**Kevin Cox C1650**

01 July 2024

**Reference: 23/02715/REM**

**Location: Land North Of Bicester Avenue Garden Centre, Oxford Road, Bicester**

PROJECT BICESTER ARC - PLOT 1 - OFFICE BUILDING	
TITLE CYCLE STORE & BINS

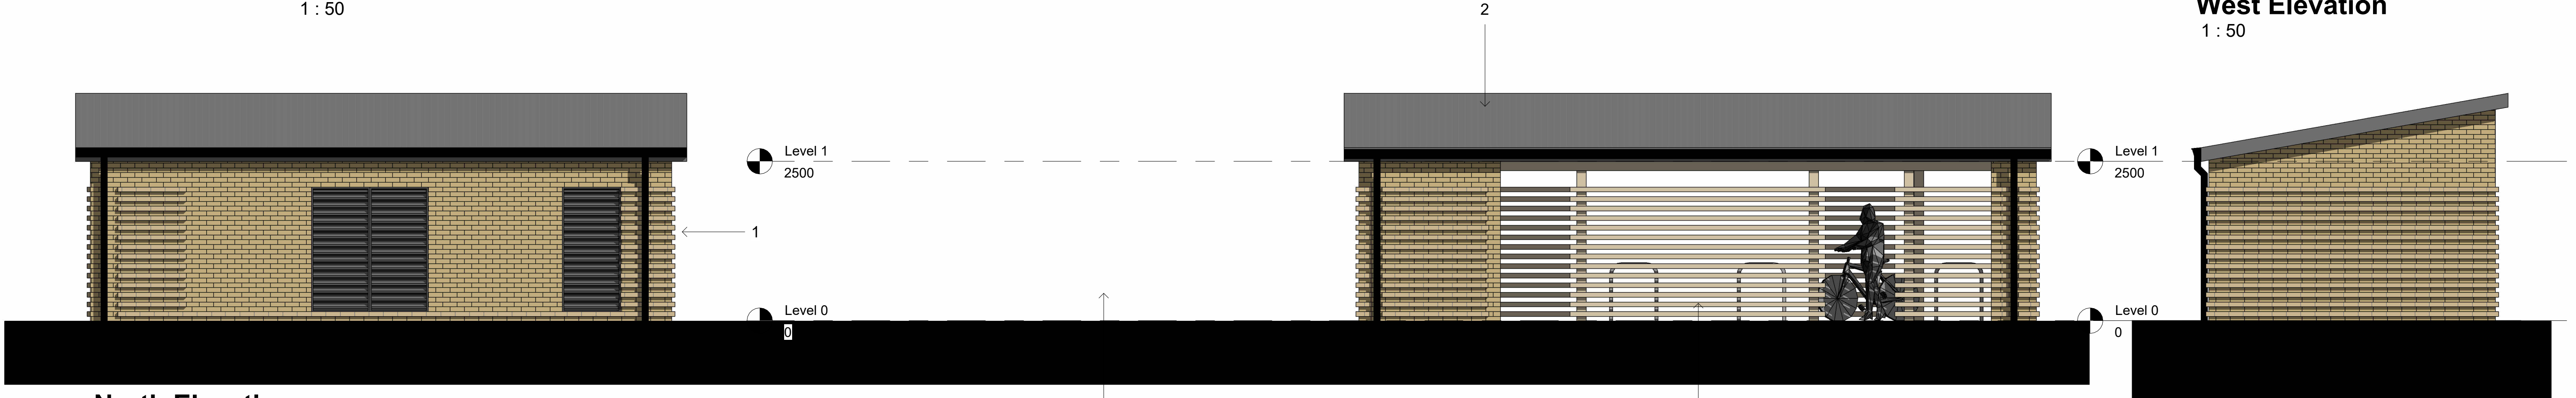
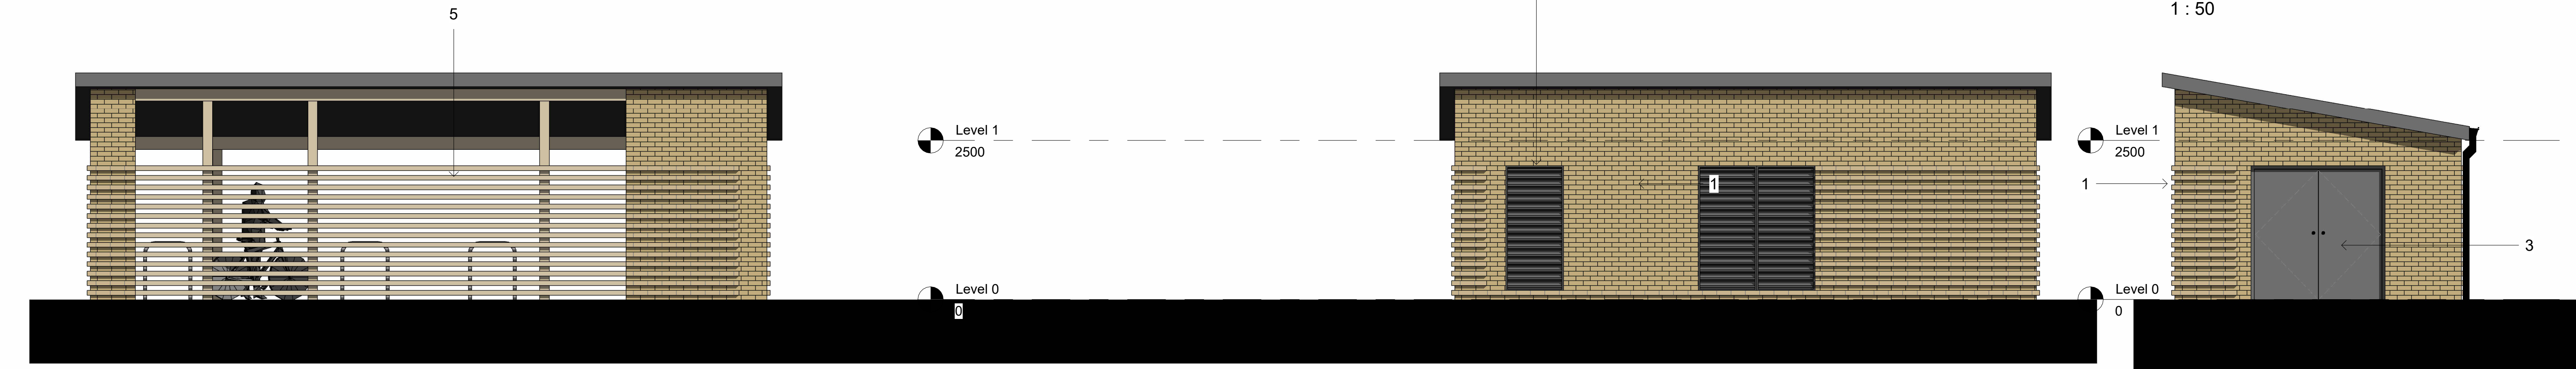
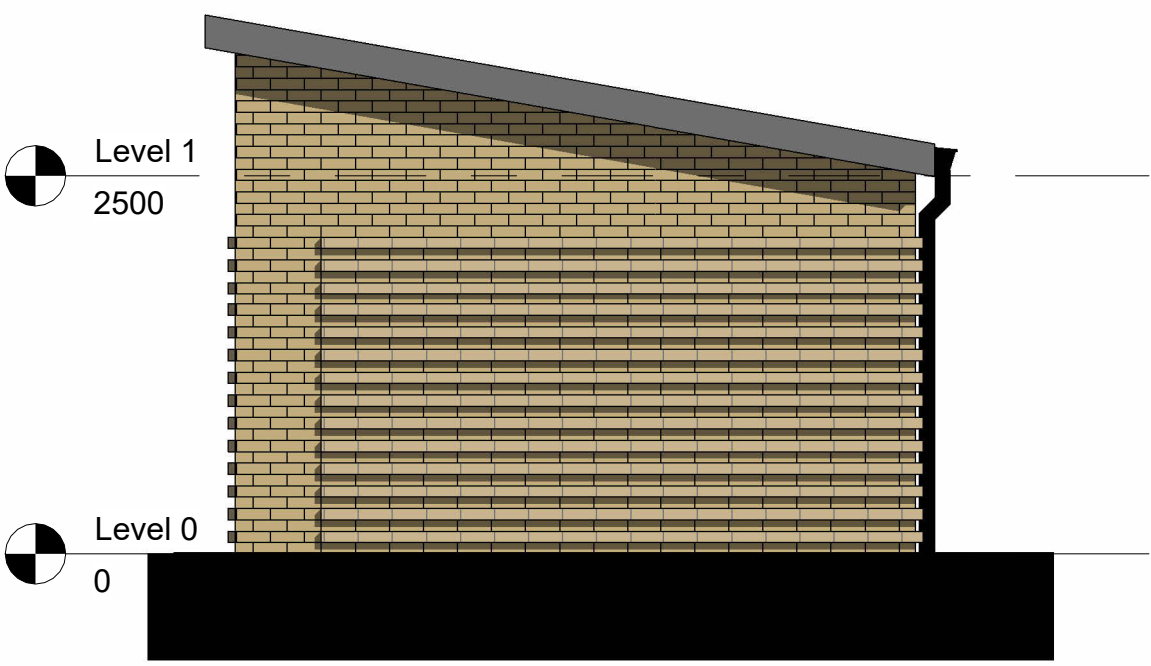
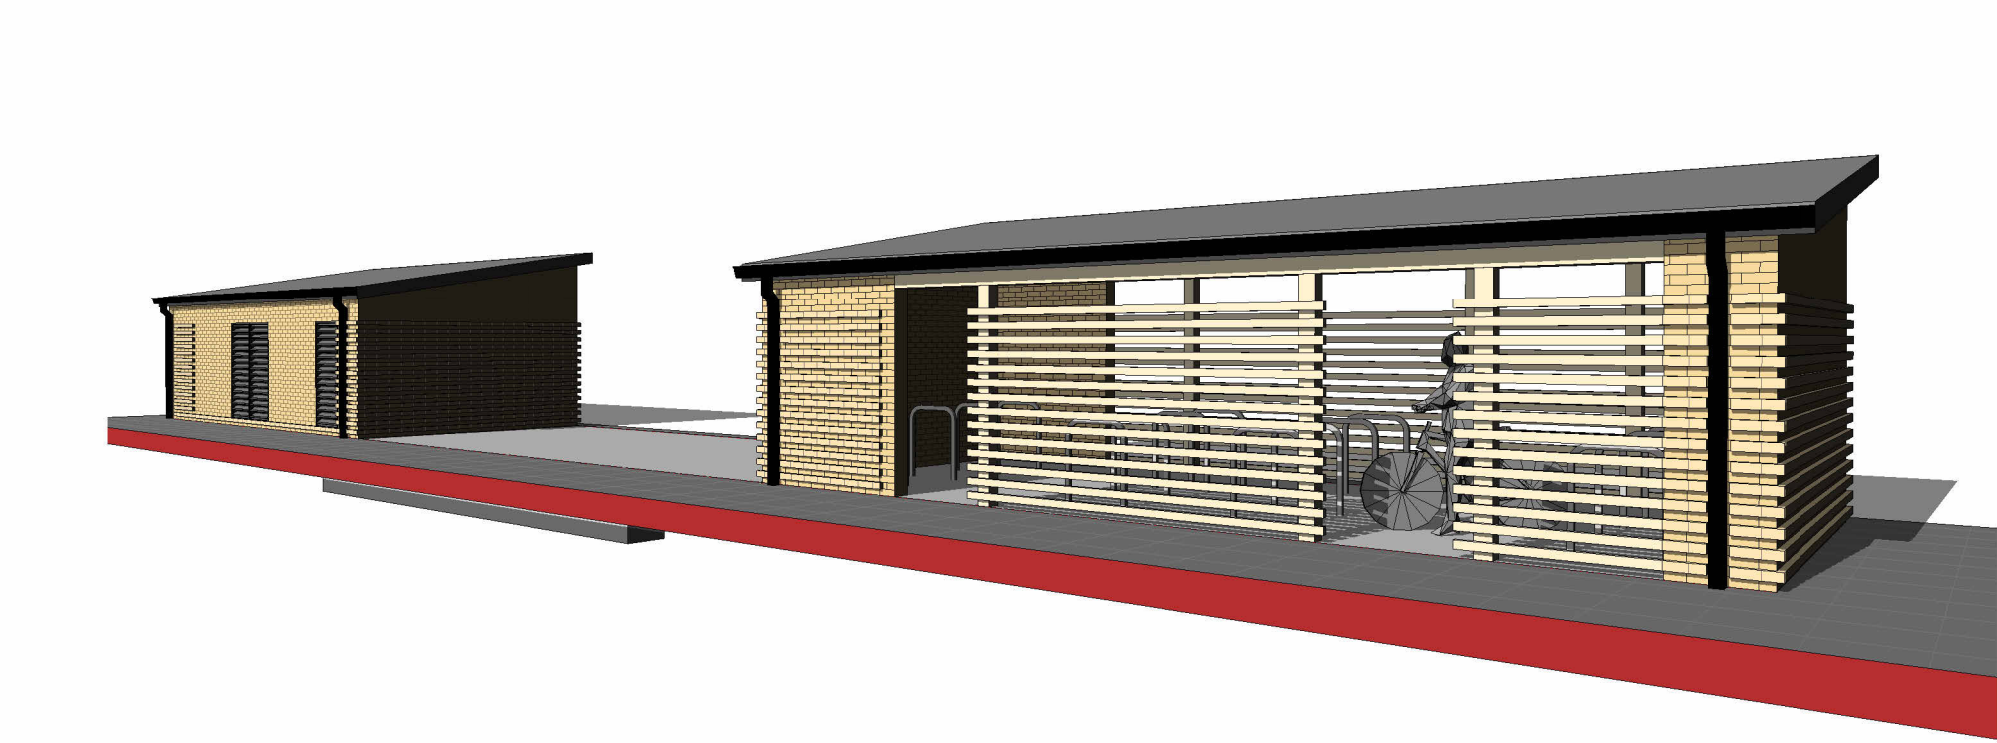
- Cycle storage facilities should be covered by CCTV and be lit.
- Depending on the nature of waste being stored, it may be necessary for the bin stores to have enhanced security secured to LPS 1175 SR2/B3. Enclosures should be fully covered by CCTV.
